25 November 2021

**Re: SSD-10396**  
**Sell & Parker Pty Ltd**  
**23-45 Tattersal Road, Kings Park**

In response to Sydney Water's letter dated 1 October, 2021 in relation to SSD-10396 we offer the following response:

Figure 3: Amended On-site Stacking Plan

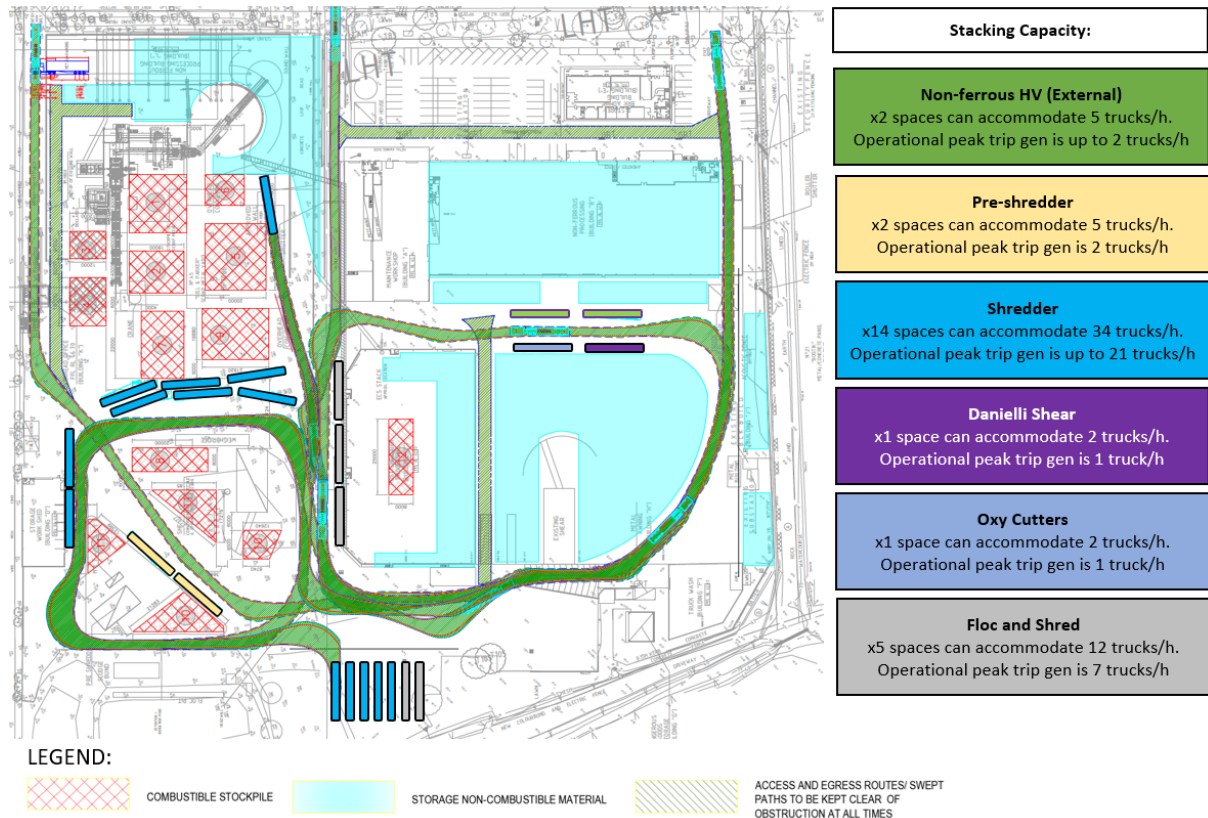
Comment	Response
Sydney Water has no objection to the proposal in principle.  However, we note there are multiple 525mm branch wastewater mains traversing the site.	Noted
Although the proposed development involves no demolition or construction works, Sydney Water understands the proposed position of heavy machinery stacking over and adjacent to the branch main running parallel with the centre north-south property boundary within the site poses potential risks to our assets.	Confirming that this application does not include any proposed demolition or construction works.  There will be no 'heavy machinery' stacking over and/or adjacent to the branch main running parallel with the centre north south boundary within the site.  Sydney Water have been provided with the TTPP report which demonstrates clearly that there is no heavy machinery stacking in those areas indicated or at all. This report is <b>attached</b> to this letter.

Considering the size and importance of these branch mains, such loading may not be permissible, and the proponent may need to create exclusion zones for these critical assets to avoid any heavy machinery movements occurring over them.	<p>The Traffic Management Plan and Stockpile Plan, describe a strategy of traffic and thoroughfare only over the 525 dia Sewer asset. All loading and unloading is to be performed remote of the location of the assets.</p> <p>All heavy machinery associated with the loading and unloading also, will be remote of location the asset.</p> <p>A more detailed response shall be provided by the WSC as part of the Section 73 response.</p>
In addition, pre and post CCTV survey of the pipes that are at risk due to proposed work (despite the asset protection plan) is required to ascertain that our asset integrity is protected during the course of this project. Condition of the sewer needs to be incorporated into the assessment.	<p>There are no works to be undertaken and this will be reflected in the SEA report through the BPA application.</p> <p>Further Sydney Water has indicated in writing on 9 November, 2021 that the pipes have been assessed by Sydney Water through CCTV footage and report and that the service condition issues (roots and grease build up) and will be dealt with as part of the Sydney Water networks normal ongoing maintenance program.</p> <p>Given our assessment and the response of Sydney Water, it is not proposed that a post CCTV survey of the pipes is required.</p>

1. Traffic Management Plan, prepared by **TTPP Transport Planning**, referenced "Metal Recovery Facility Kings Park, Swept Path Analysis 19m Articulated vehicle Project No. 19237 Drwg No. 19237Cad04 dated 17 November 2021; and
2. stockpile plan **Final Stockpile Plan Revision 02 dated 28 July, 2021** prepared for Sell & Parker Pty Ltd, and approved in Land and Environment Court proceedings [2021] NSWLEC 1563 and Fire Rescue NSW on 6 August 2021 as annexed to this report.
3. Sydney Water email dated 9 November, 2021.
